MONUMENT FIRE DISTRICT
16055 Old Forest Point, Suite #102
Monument, CO 80132
(719) 484-0911
www.monumentfire.org
Proudly serving the Tri-Lakes Region

To: Development Review, El Paso County
From: Jonathan Bradley, Fire Marshal
Subject: Urban Landing PUDSP
Date: July 31, 2024

The Monument Fire District has reviewed the PUD development plan for Urban Landing. Based on our initial review of site access, water supply, and fire mitigation, we have the following comments.

FIRE TRUCK SIZE:
8.3' WIDE
43.4' LONG

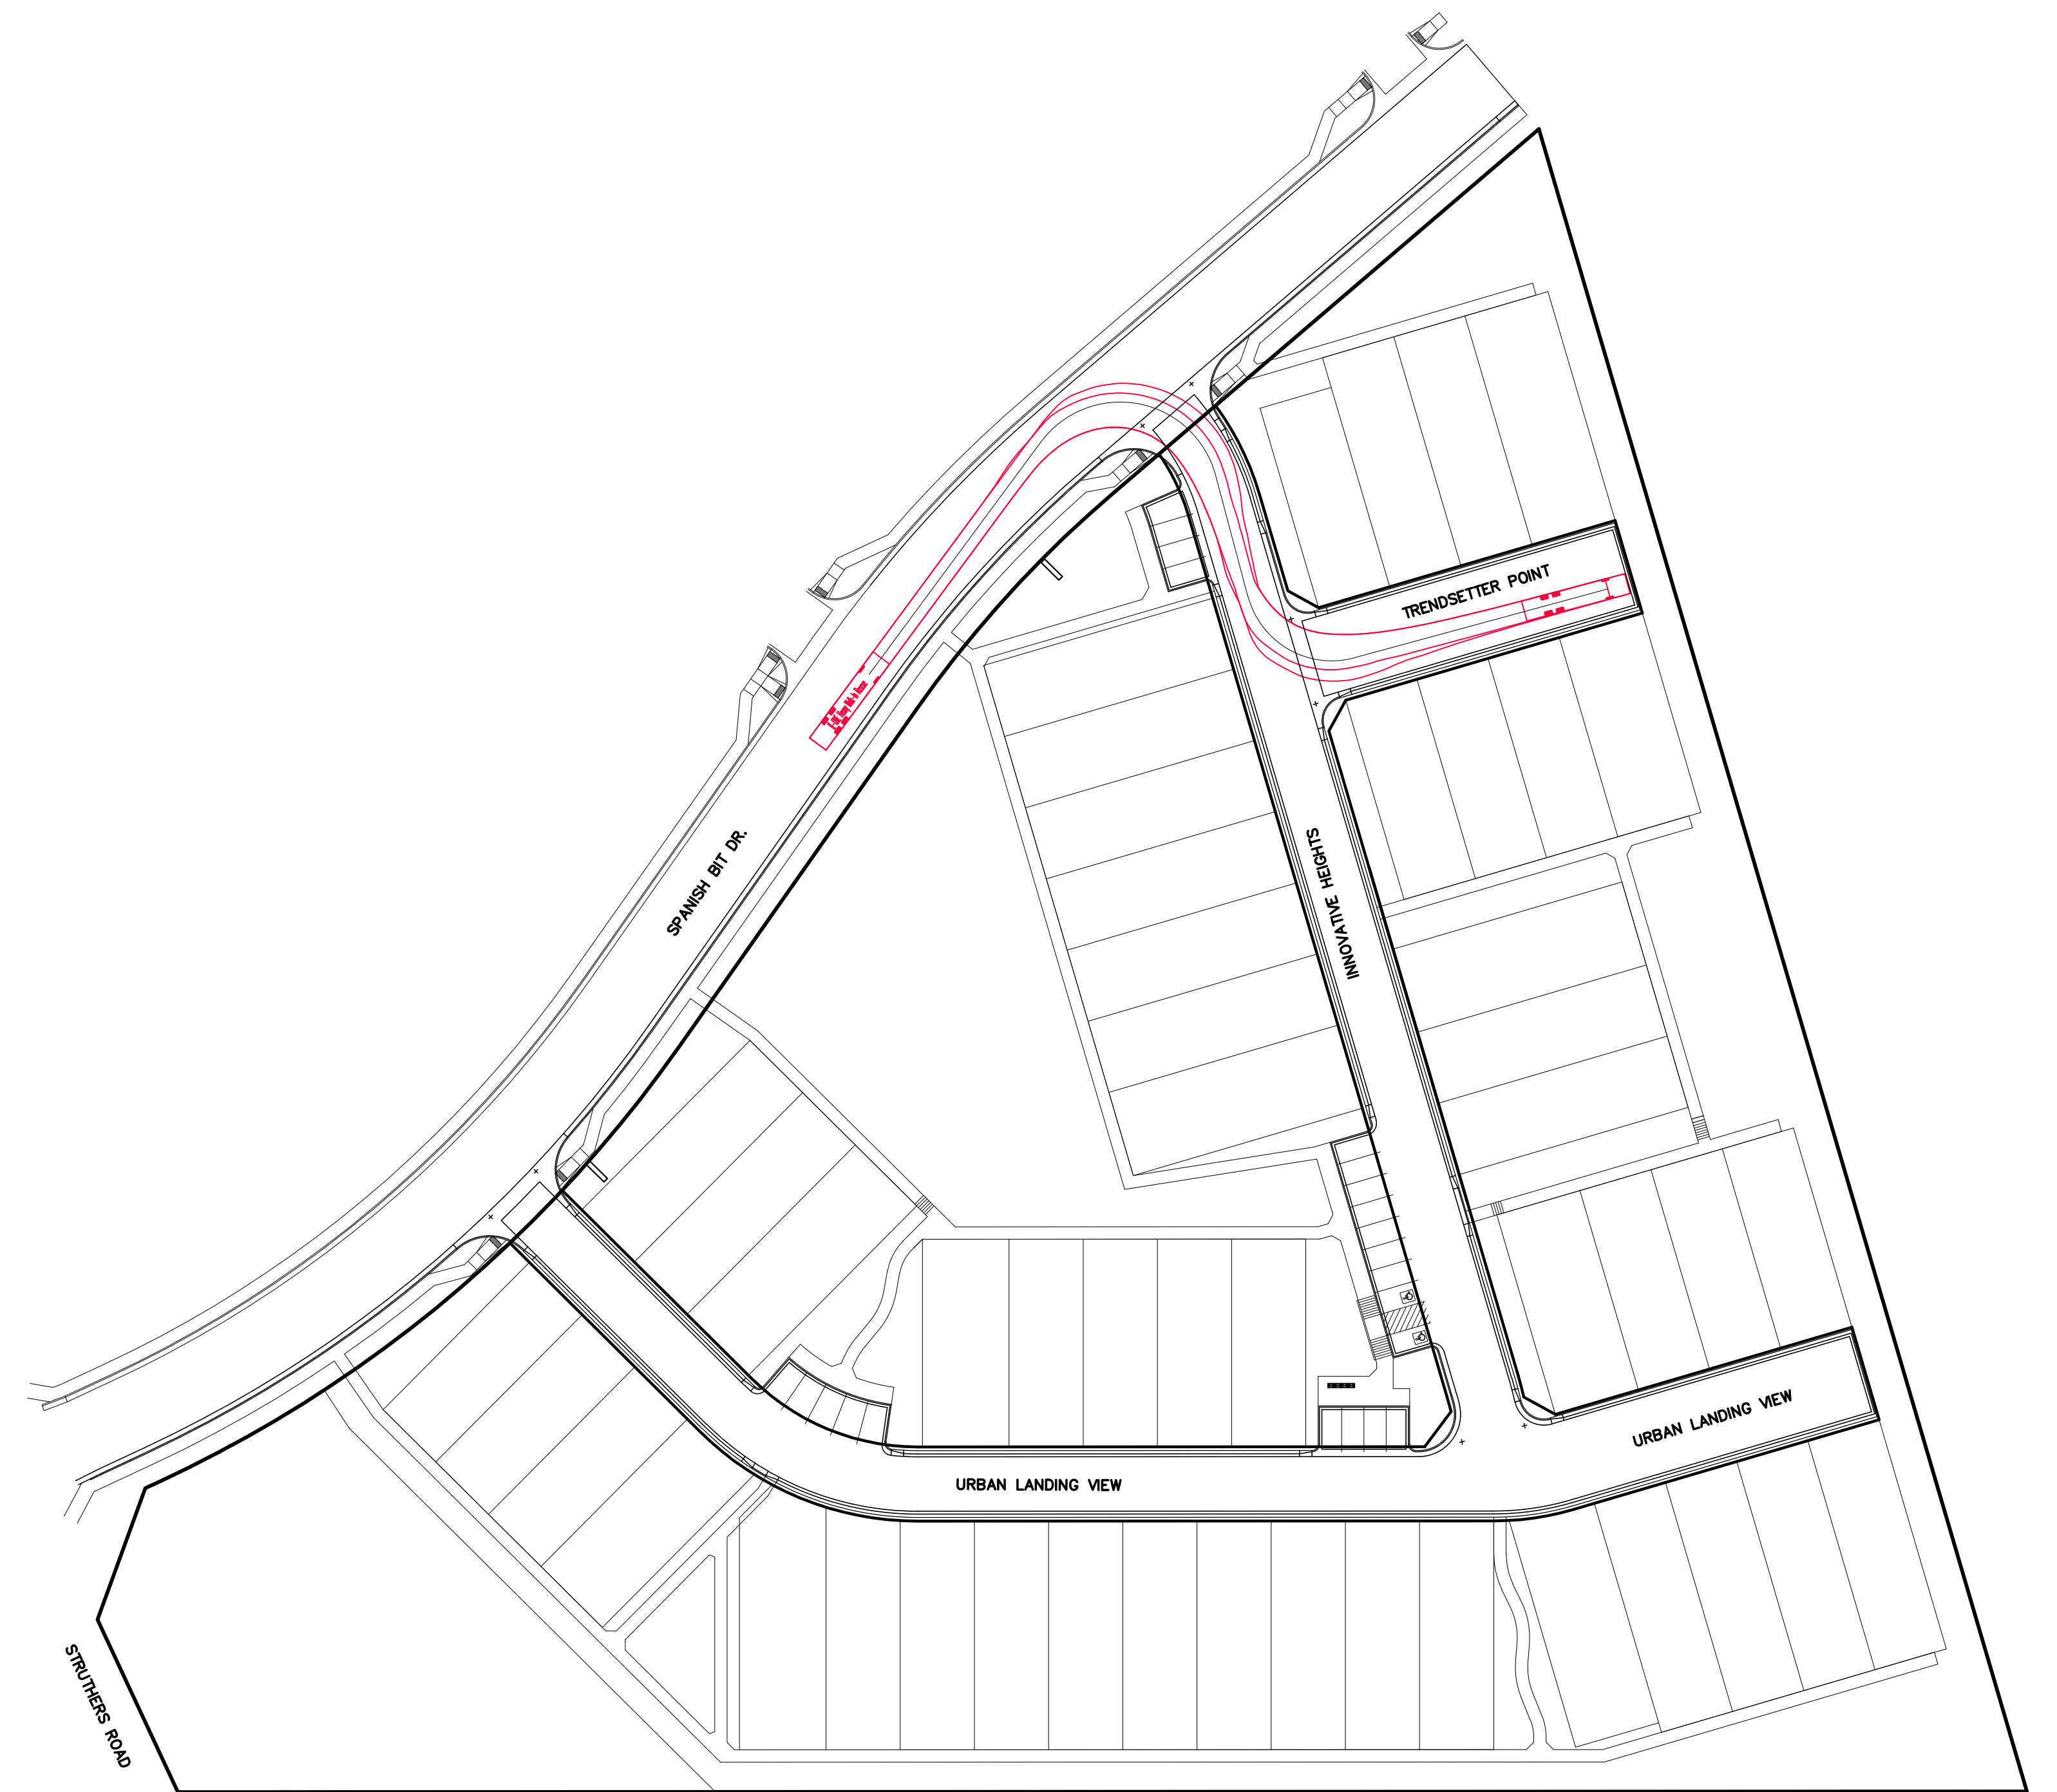
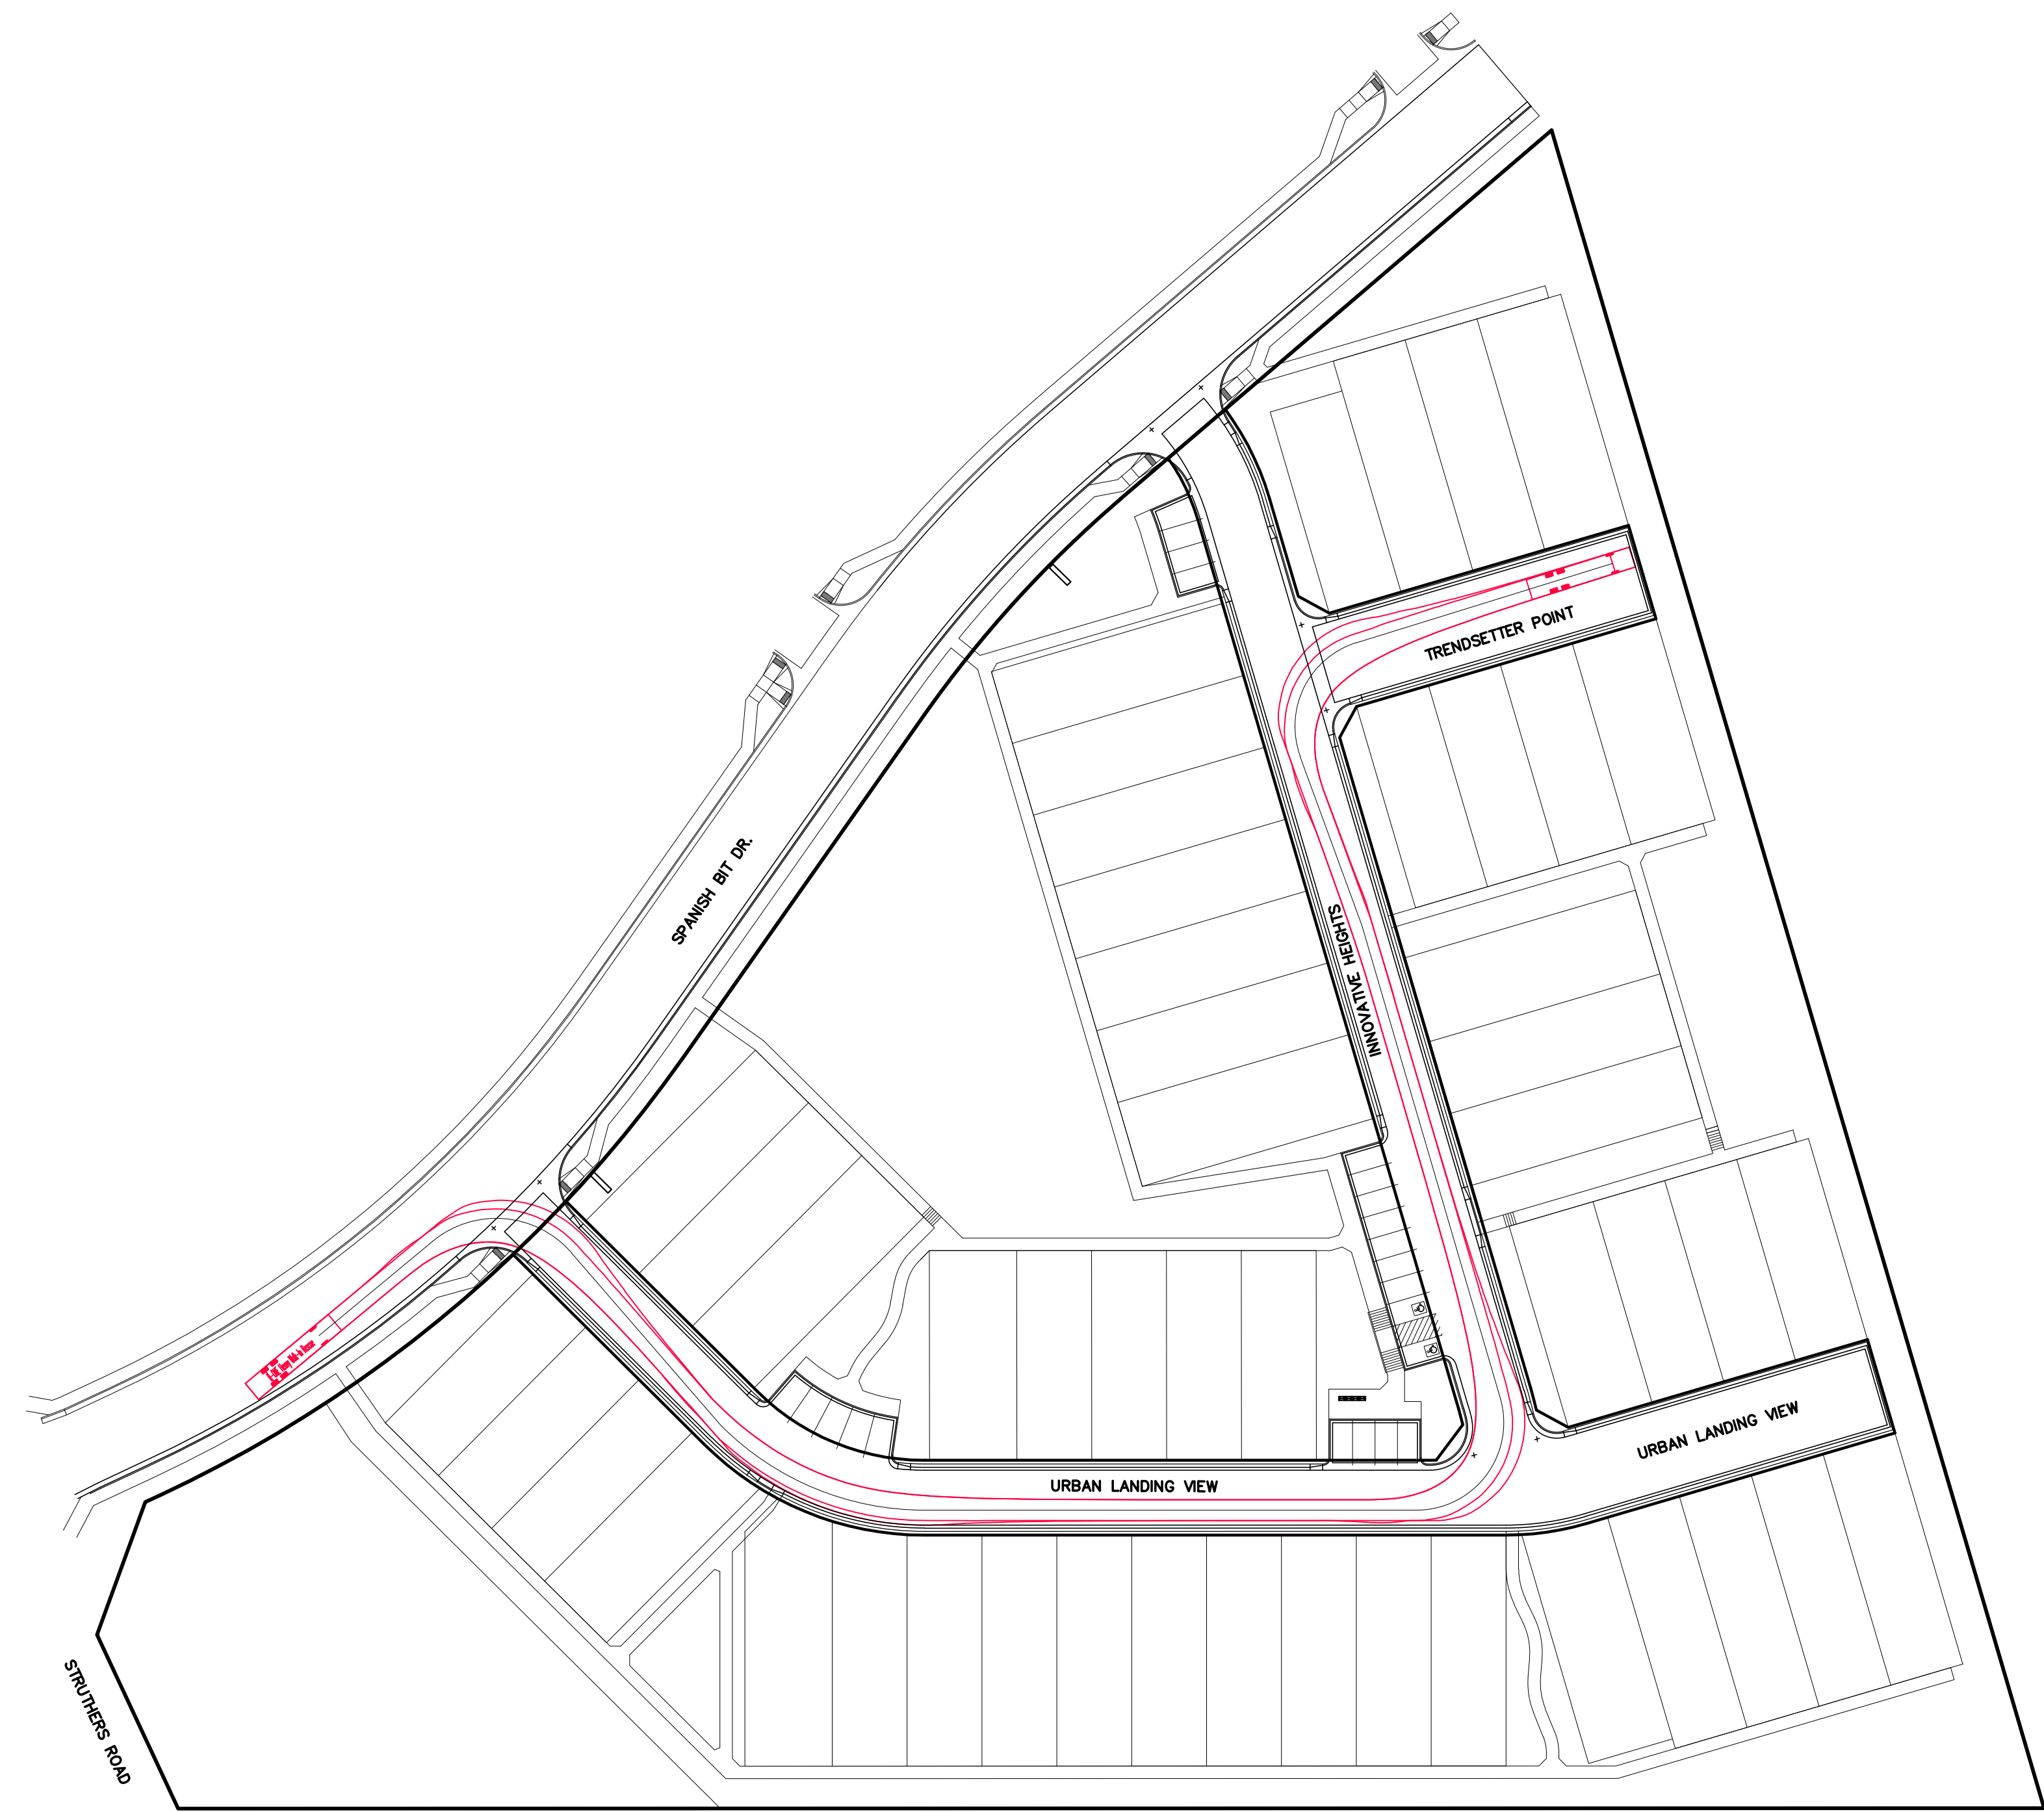
- FD prefers EPC Optional Type C curb and Gutter throughout the development (except designated parking areas) due to narrow roadways to allow large fire apparatus to mount the curb while turning or passing without damaging wheels and tires (see page 3 of 9 in PUD Development Plan).
- Evaluate turning radius for attached fire apparatus drawing and determine if proposed roadways will accommodate large vehicle operation.
